# Rezoning Transportation Analysis

Petition Number: 2022-140

**From: Jake Carpenter, PE**  
Jacob.carpenter@charlottenc.gov  
980-221-5675

RZ1.0

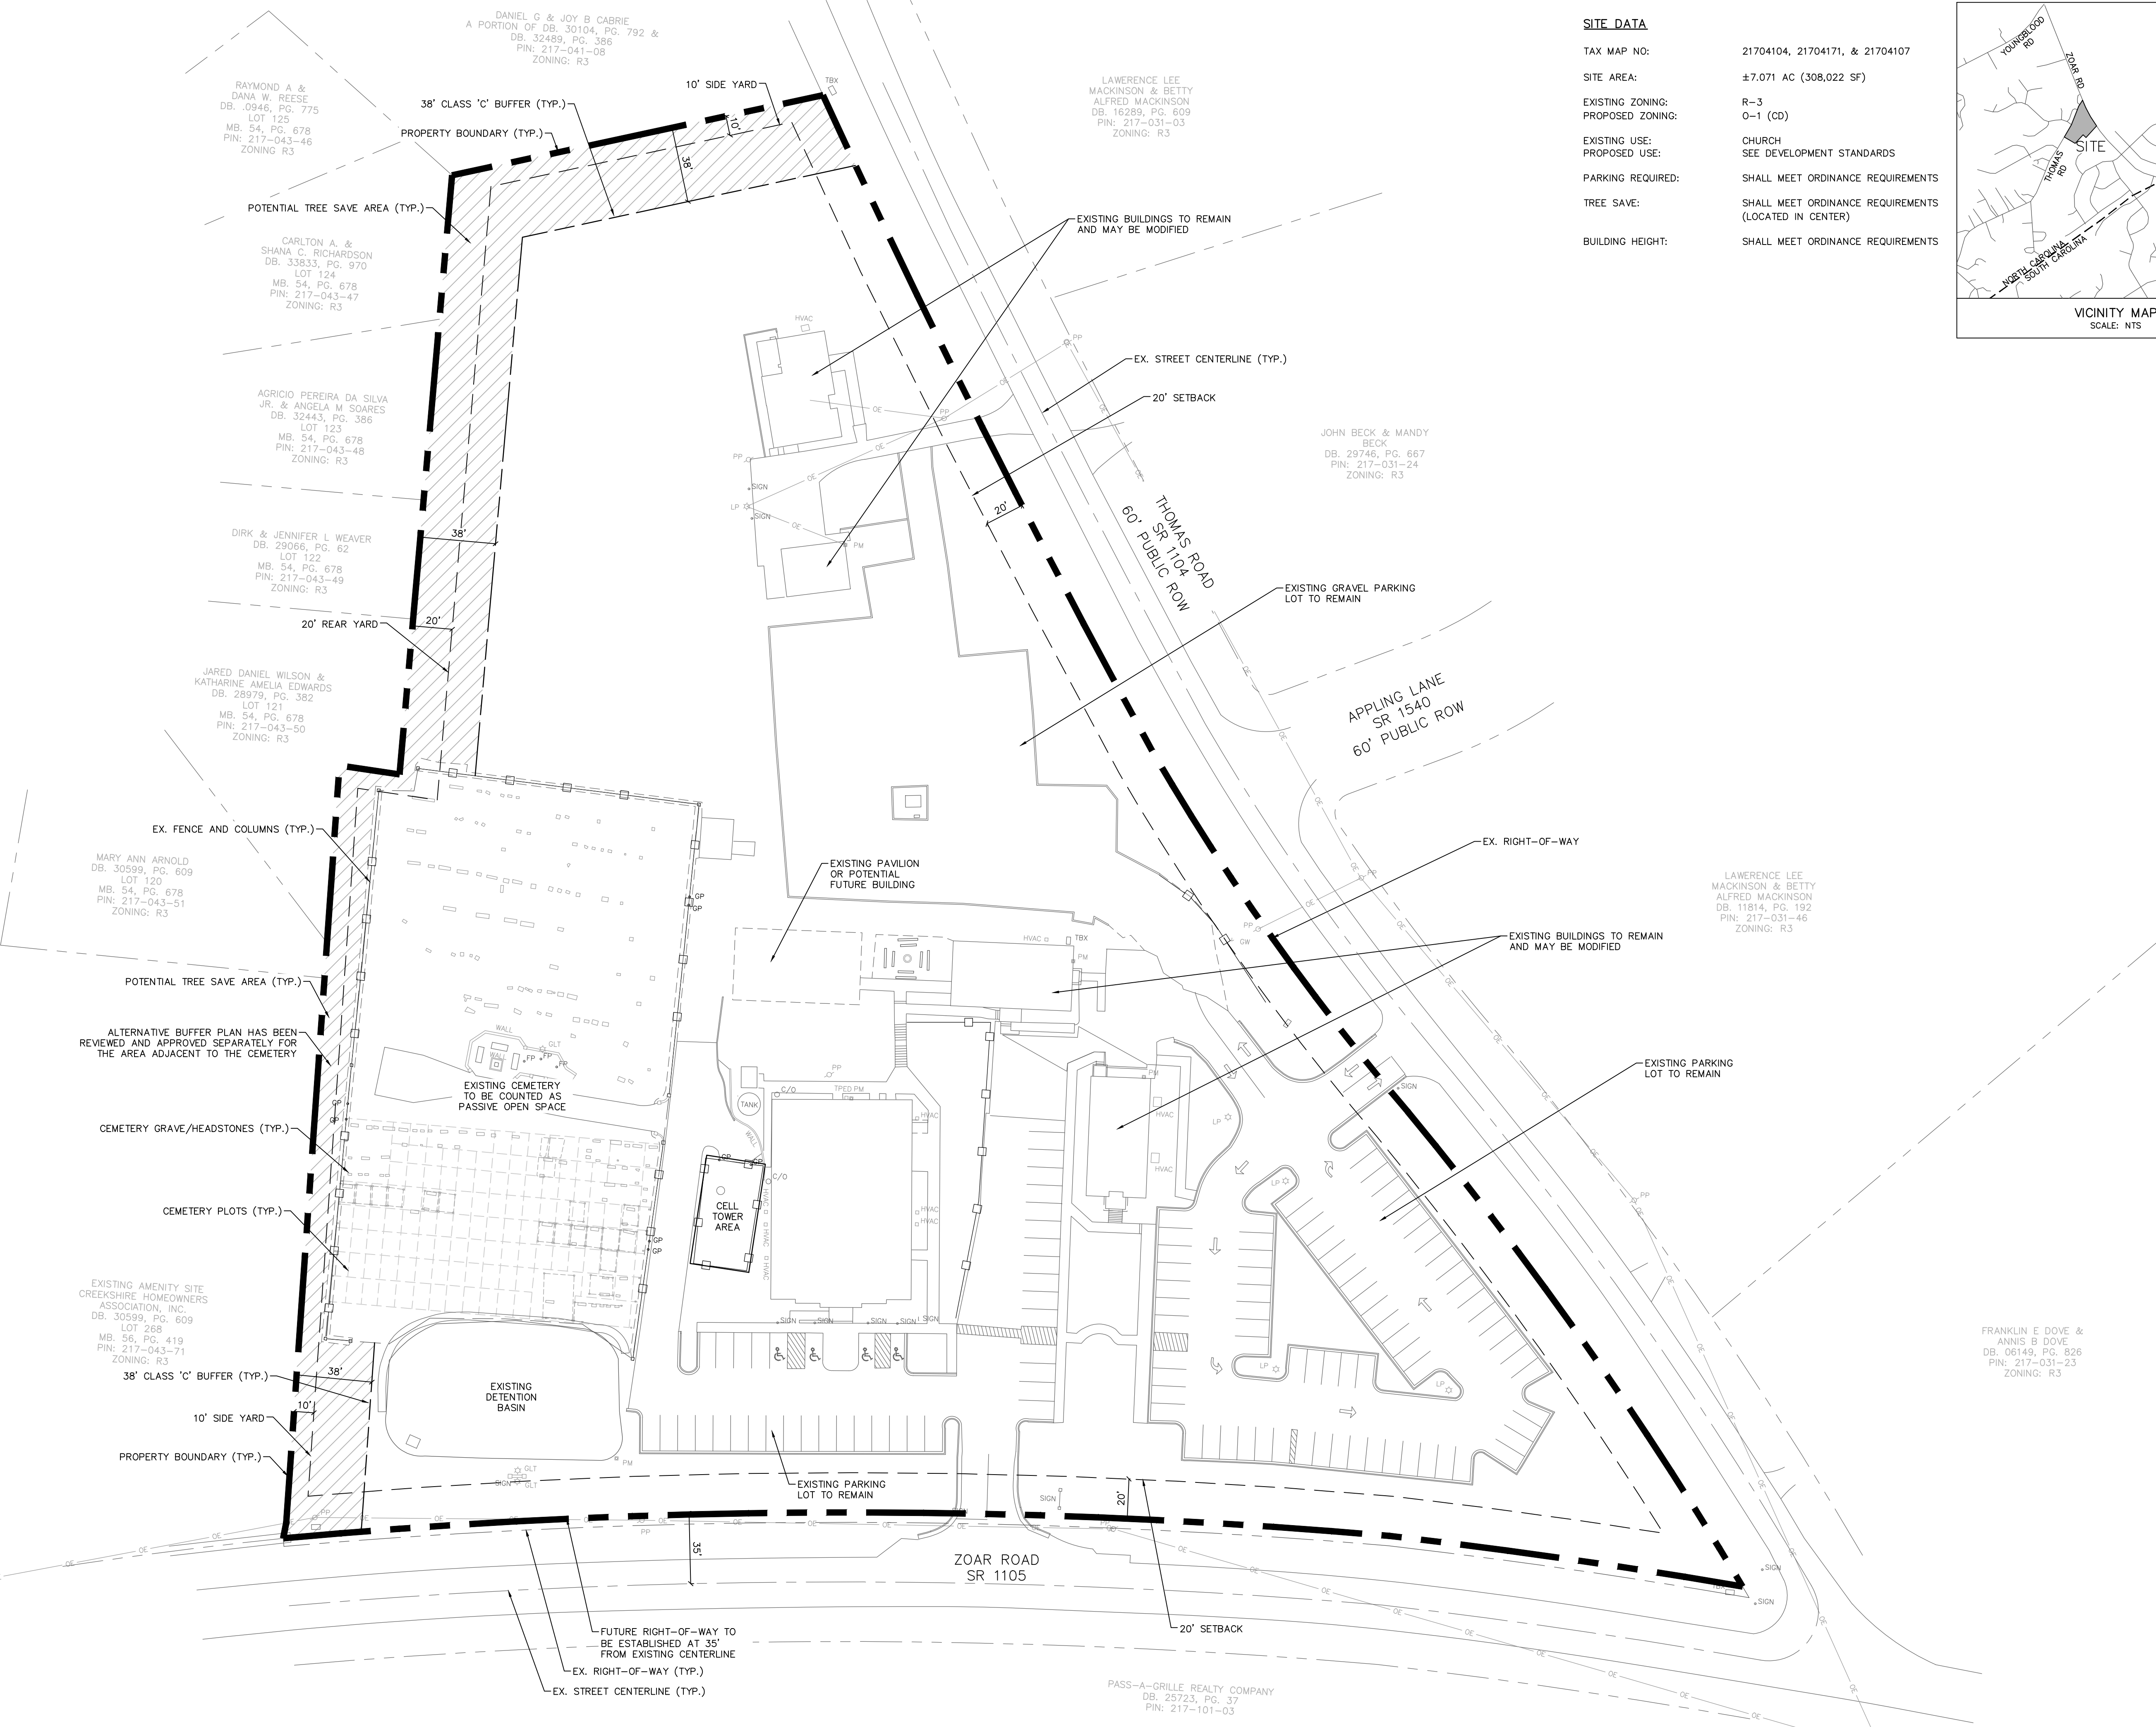
~~**Zoar Road:** Location of curb and gutter to be located 19 feet from roadway centerline to accommodate the Charlotte Streets Map with a roadway typical section of a two plus lane avenue with shared use path.~~

~~**Thomas Road:** Location of curb and gutter to be located 17.5 feet from roadway centerline to accommodate the Charlotte Streets Map with a roadway typical section of a two plus lane avenue with sidewalk. The location of curb and gutter is in accordance with CLDSM U-06 for local collector.~~

~~Label and dimension the curb and gutter from the centerline for each road on the site plan.~~

~~Clarifying Comment from 2-22-23: Dimension the future back of curb from the centerline on both Zoar Road and Thomas Road~~

~~3. Revise site plan and conditional note(s) to commit to dedicate 35 feet of right of way from the road centerline on Zoar Road. The site plan shall label and dimension the right of way from the road centerline. If greater than 35 feet of right-of-way exists dimension the existing right-of-way from the road centerline.~~

~~4. Revise site plan and conditional note(s) to commit to construct an 8-foot planting strip, and 6-foot sidewalk on Thomas Road per Chapter 19. The site plan shall label and dimension both items from the back of curb and gutter or edge of pavement.~~

~~5. Revise site plan and conditional note(s) to commit to construct bicycle facilities by installing a 12' multi-use path on Zoar Road to meet the Council-adopted Charlotte BIKES Policy. Multi-use paths maintained by the City shall meet ADA/PROWAG requirements.~~

~~Clarifying Comment from 2-22-23: Extend sidewalk on Zoar Road across the site's frontage to extend the existing pedestrian network.~~

~~Comment Update from 4-25-23: Sidewalks are not required to be constructed with this based on the scope of this petition per Chapter 19. CDOT **requests** the sidewalk is provided by the petition.~~

~~Comment Update from 4-25-23: Sidewalks/MUP facilities are not required to be constructed with this based on the scope of this petition per Chapter 19. CDOT **requests** the MUP is provided by the petition.~~
